STATE OF NORTH CAROLINA  
DEPARTMENT OF TRANSPORTATION

November 9, 2012

Subject: **Response to US Army Corps of Engineers Letter** for the proposed NC 133 Connector from NC 211-133 (Southport Supply Road) to NC 87-133 (River Road), Brunswick County, TIP R-3324.

**SITE IV**

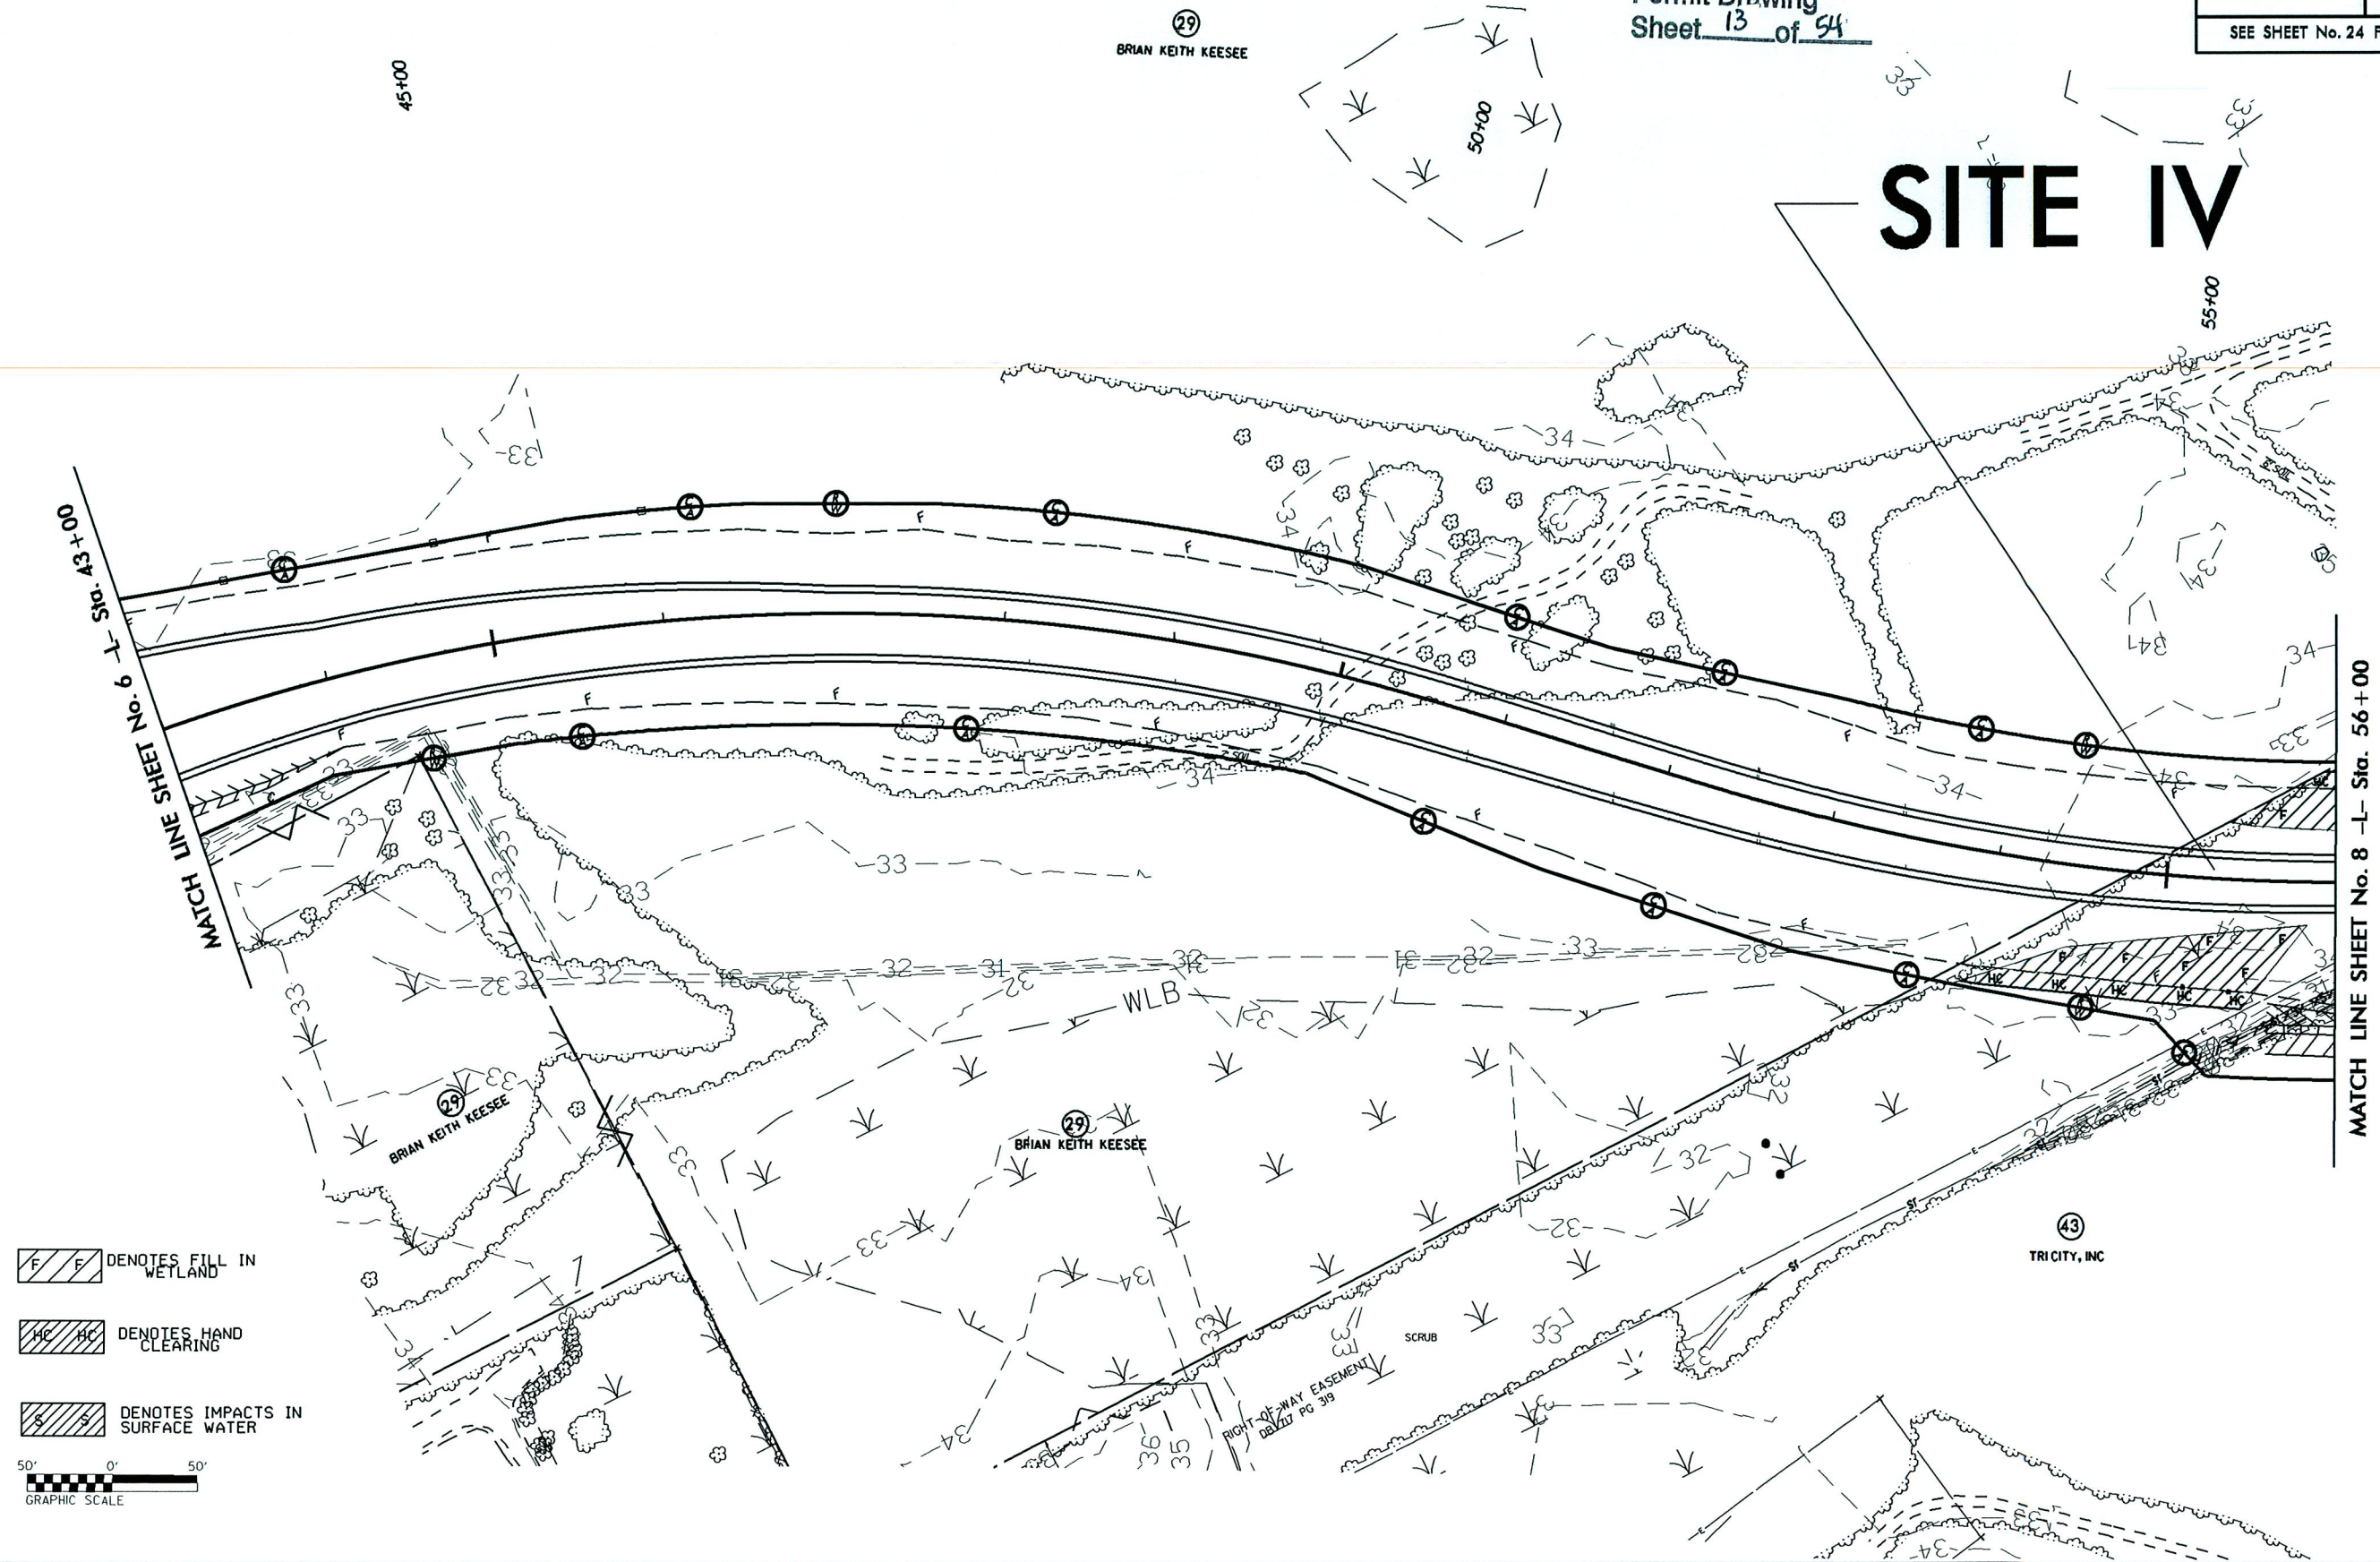
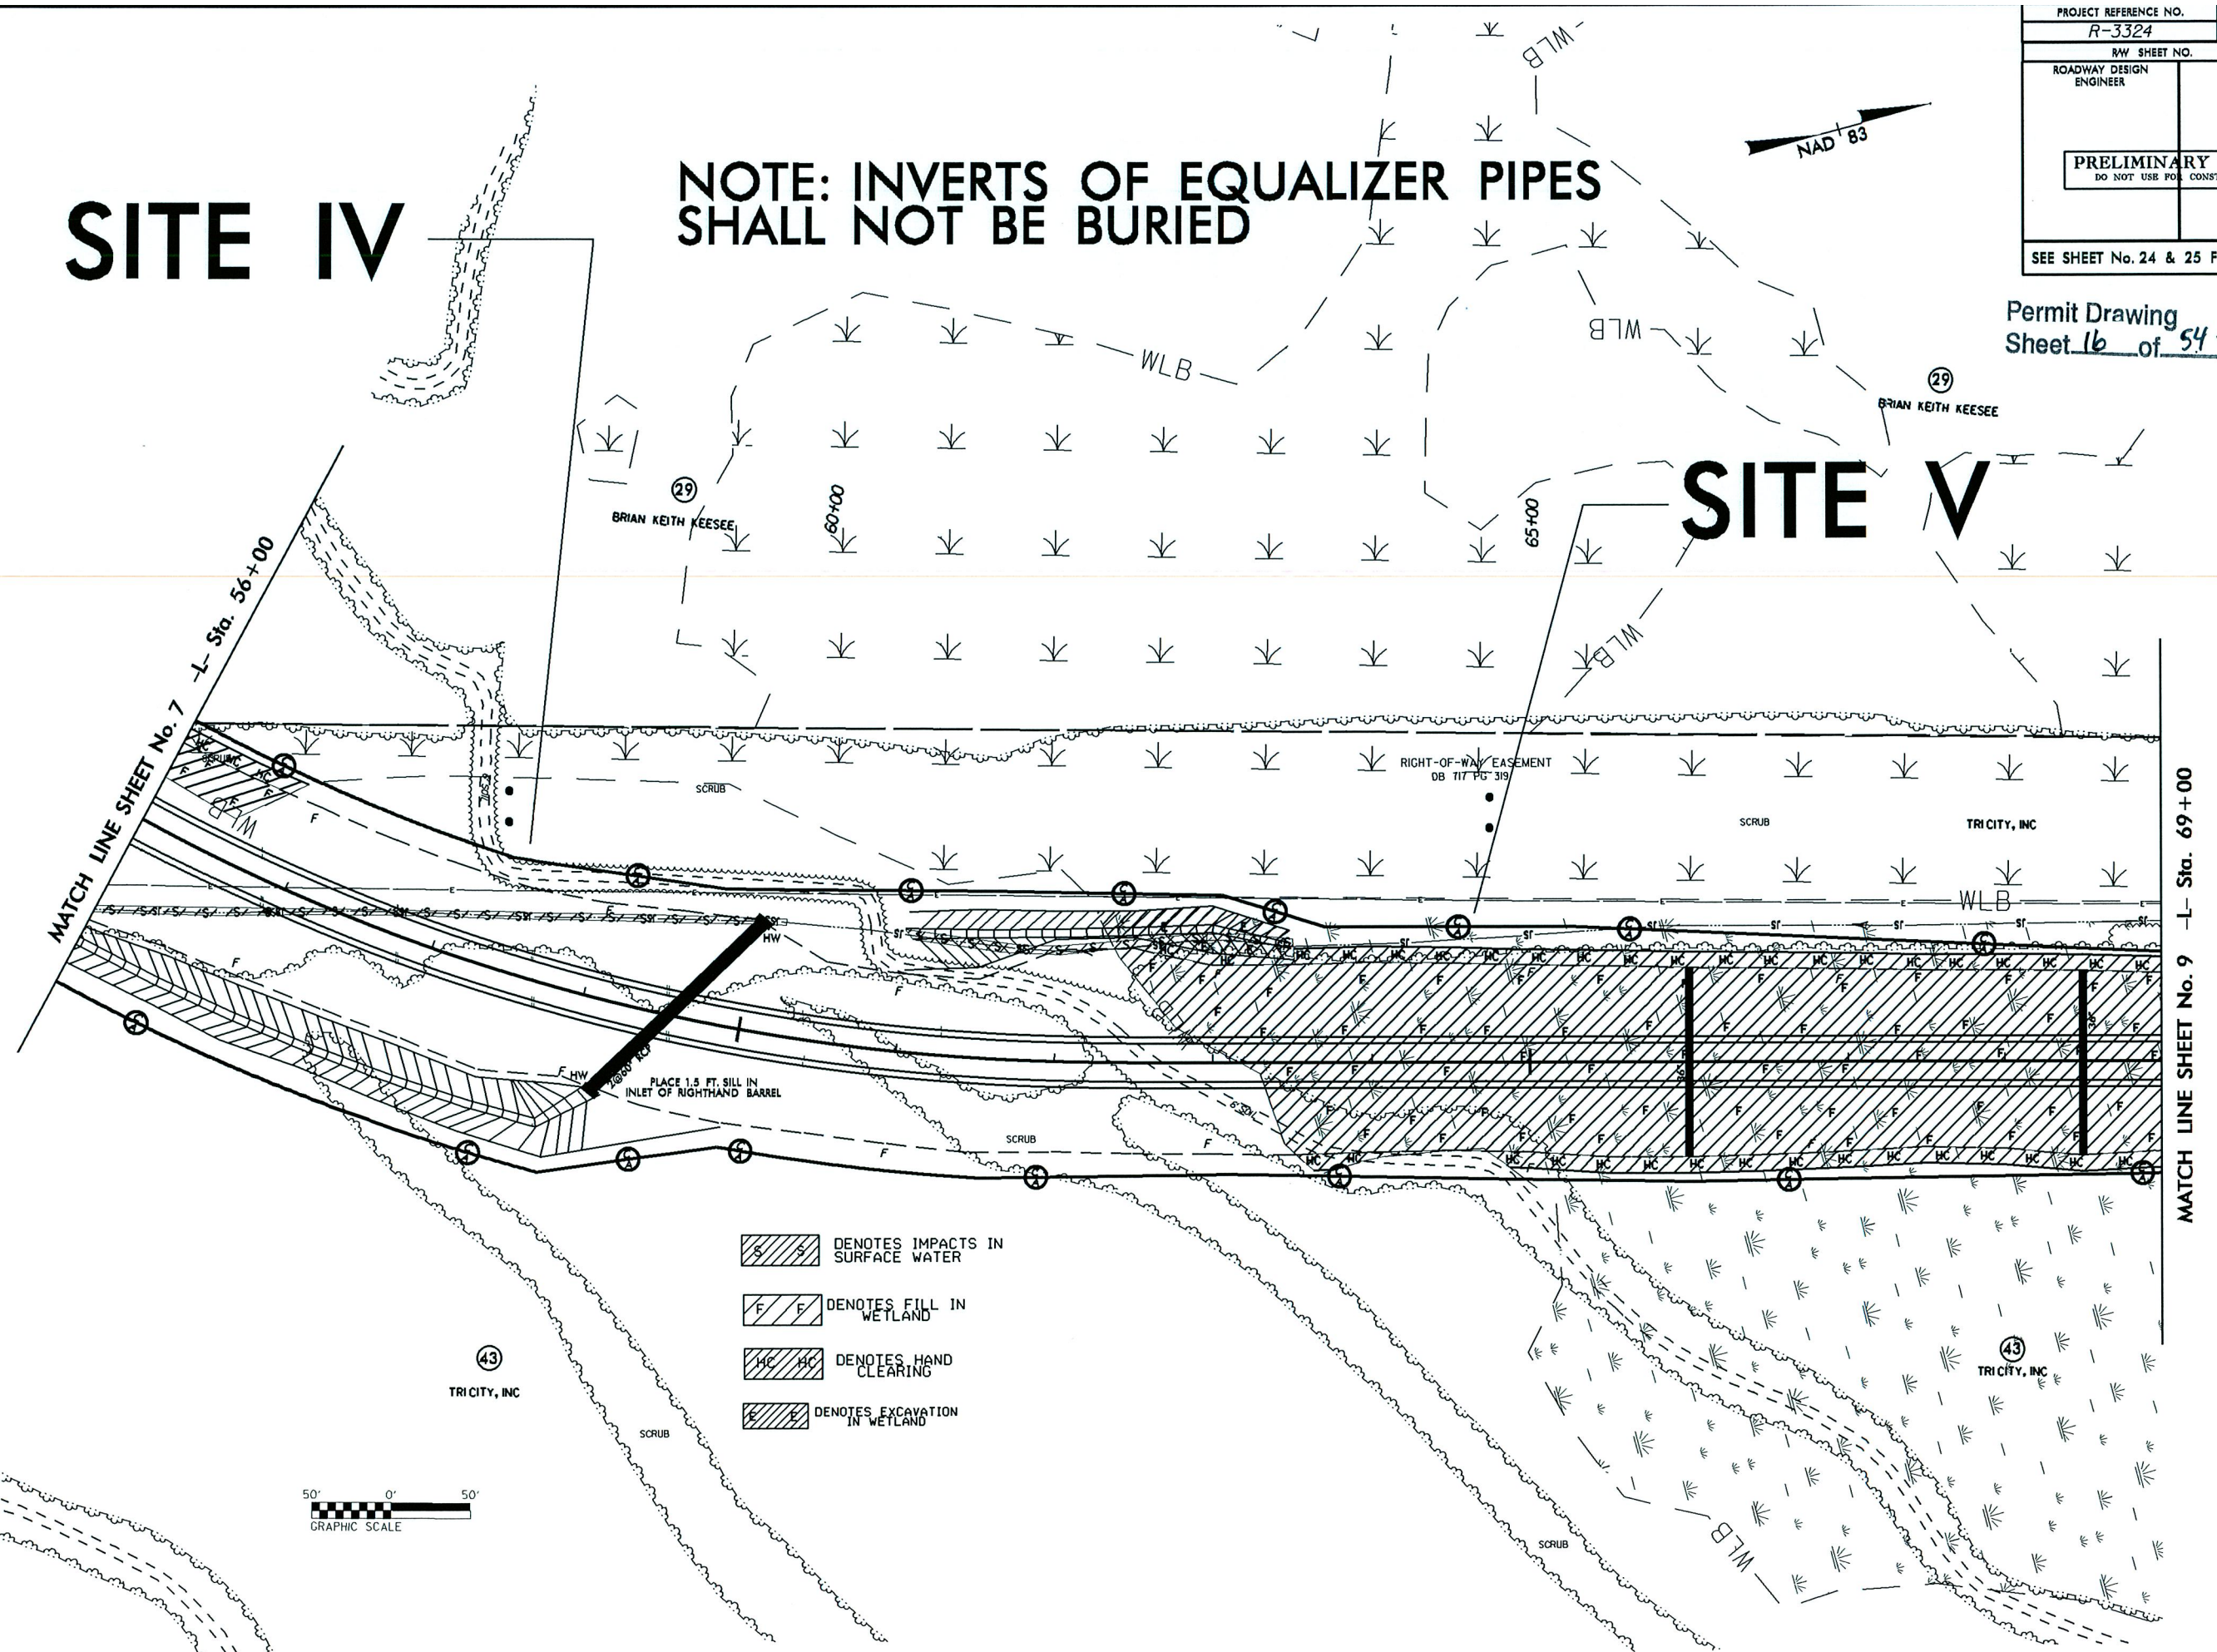
4. Site 5: *Notes equalizer pipes but does not show them in cross section drawings indicating burial or not, please clarify.*

Response provided in previous correspondence.

**NOTE: INVERTS OF EQUALIZER  
PIPES SHALL NOT BE BURIED**

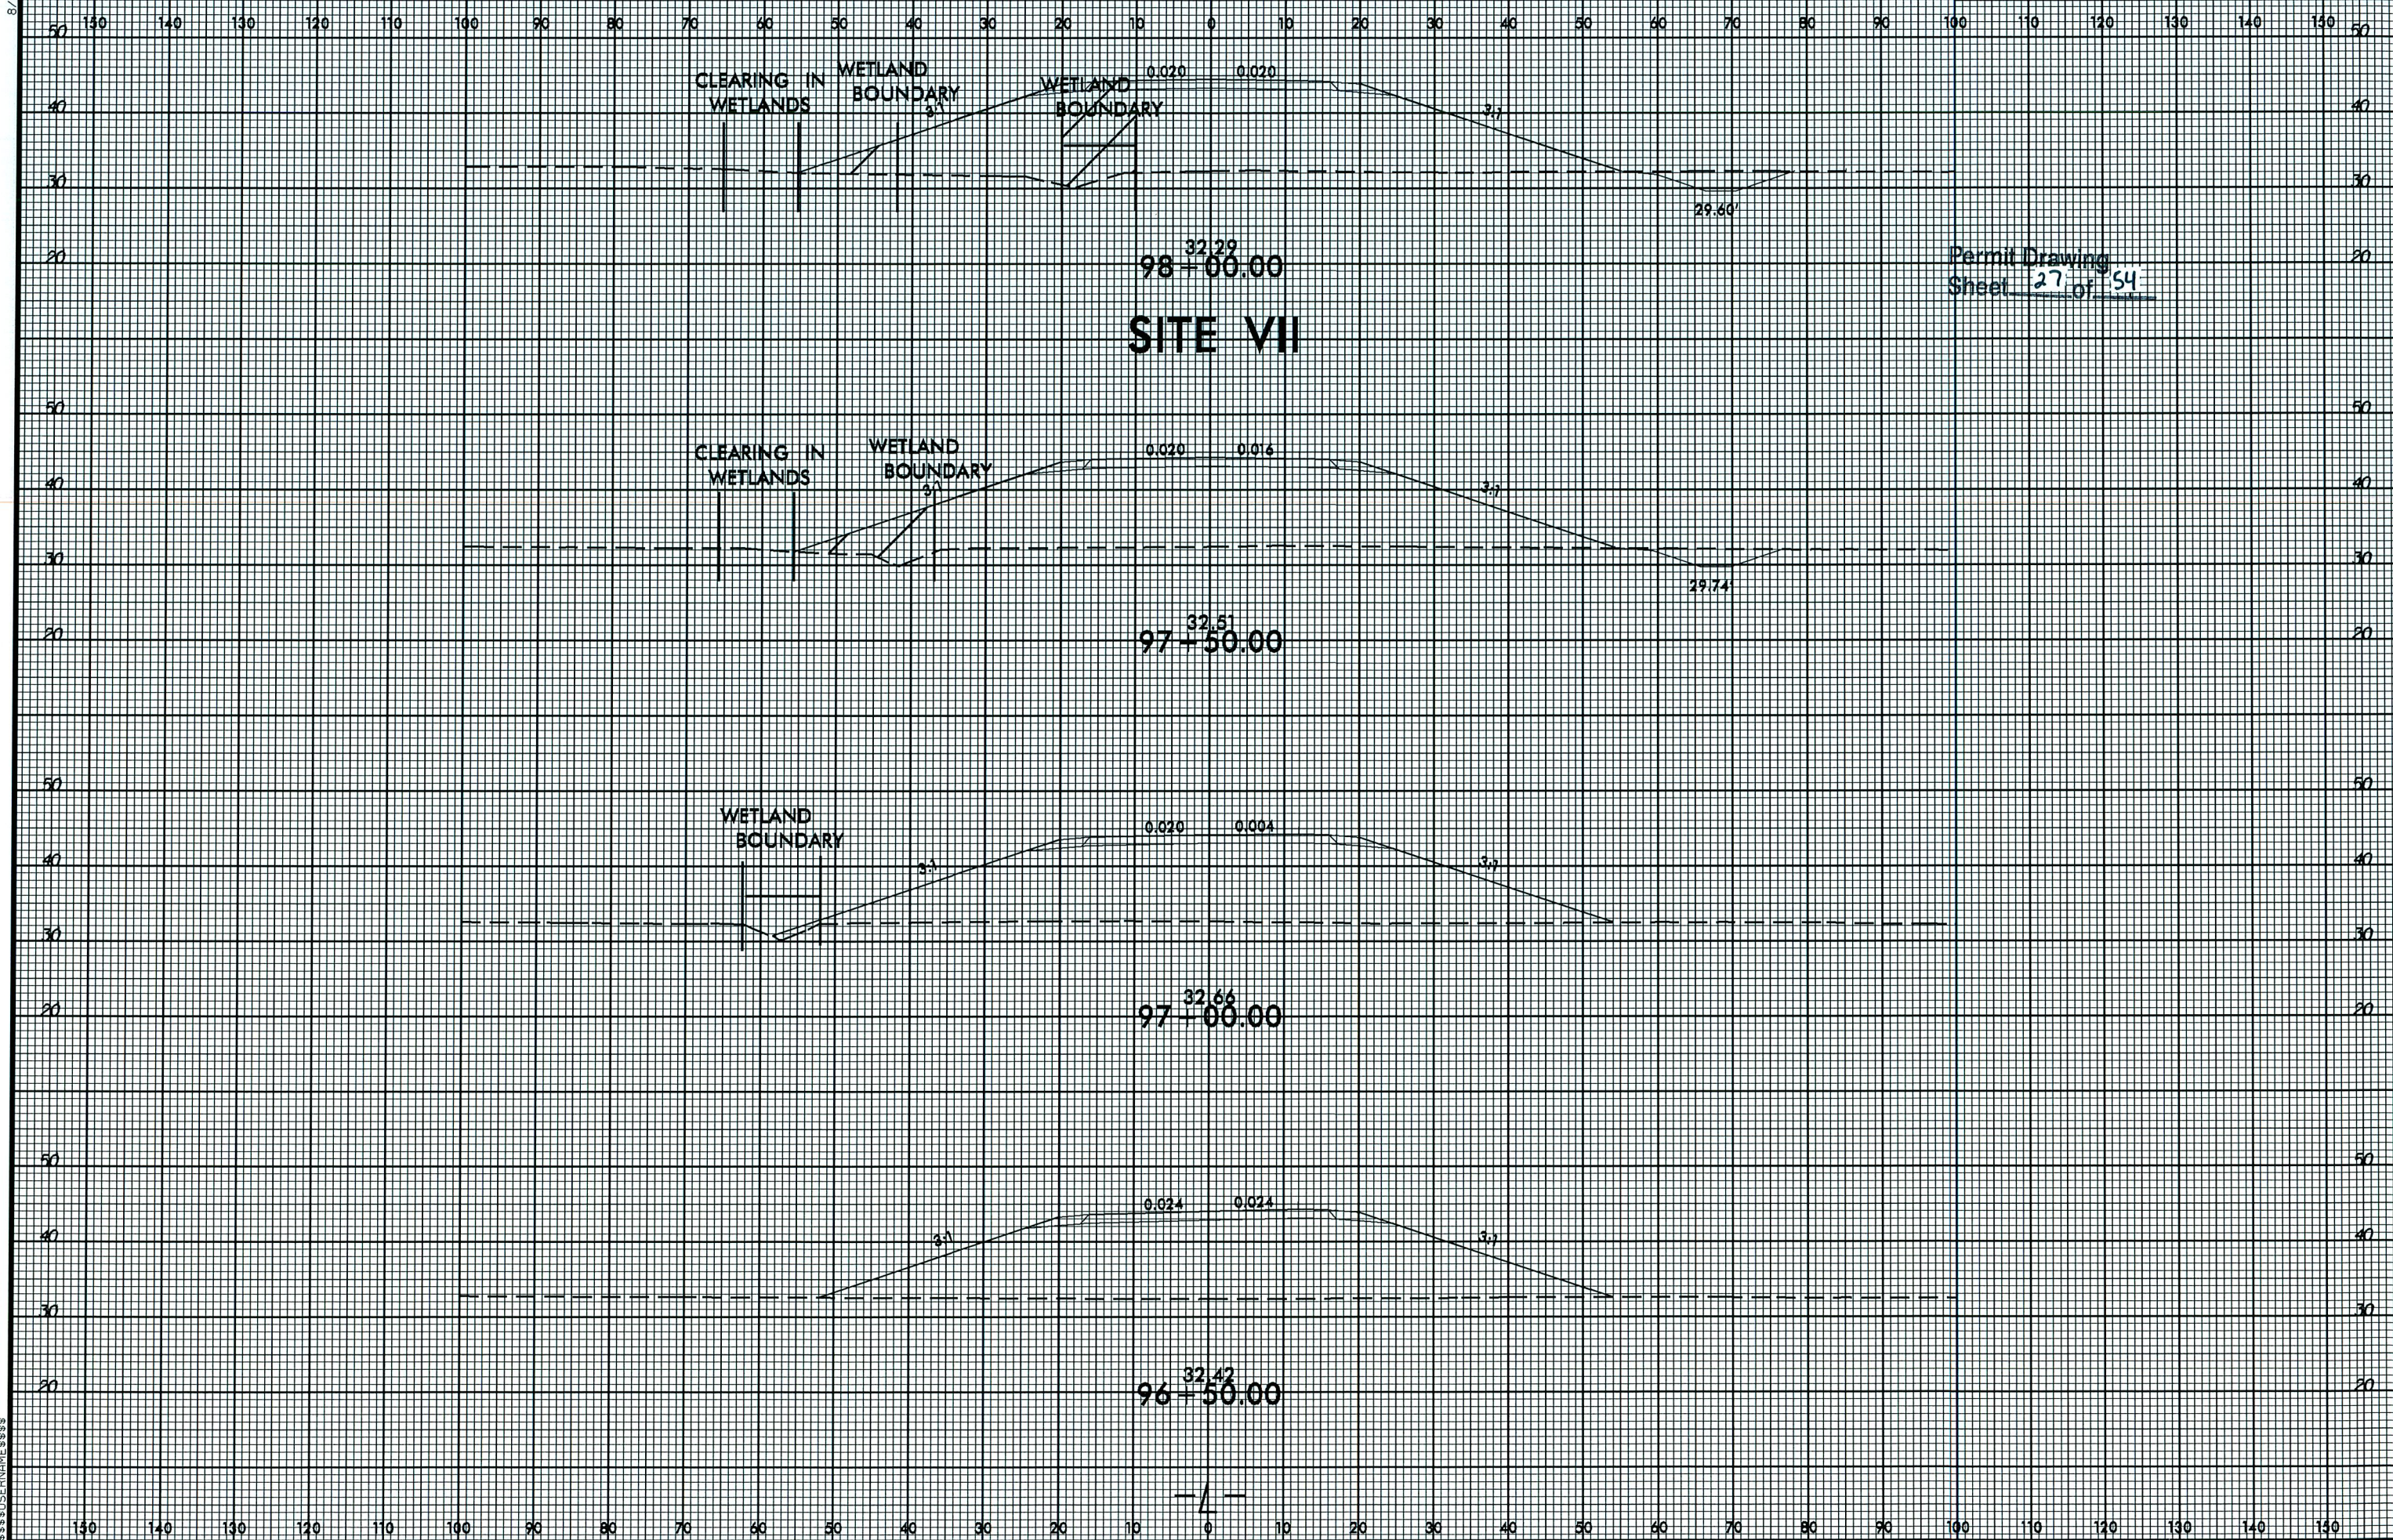
7. Sites 8 and 9: *NCDOT was asked to clarify if equalizer pipes will be buried or not on Sites 8*

The equalizer pipes at Sites 8 and 10 will not be buried. A note to this effect has been added to the permit drawings.
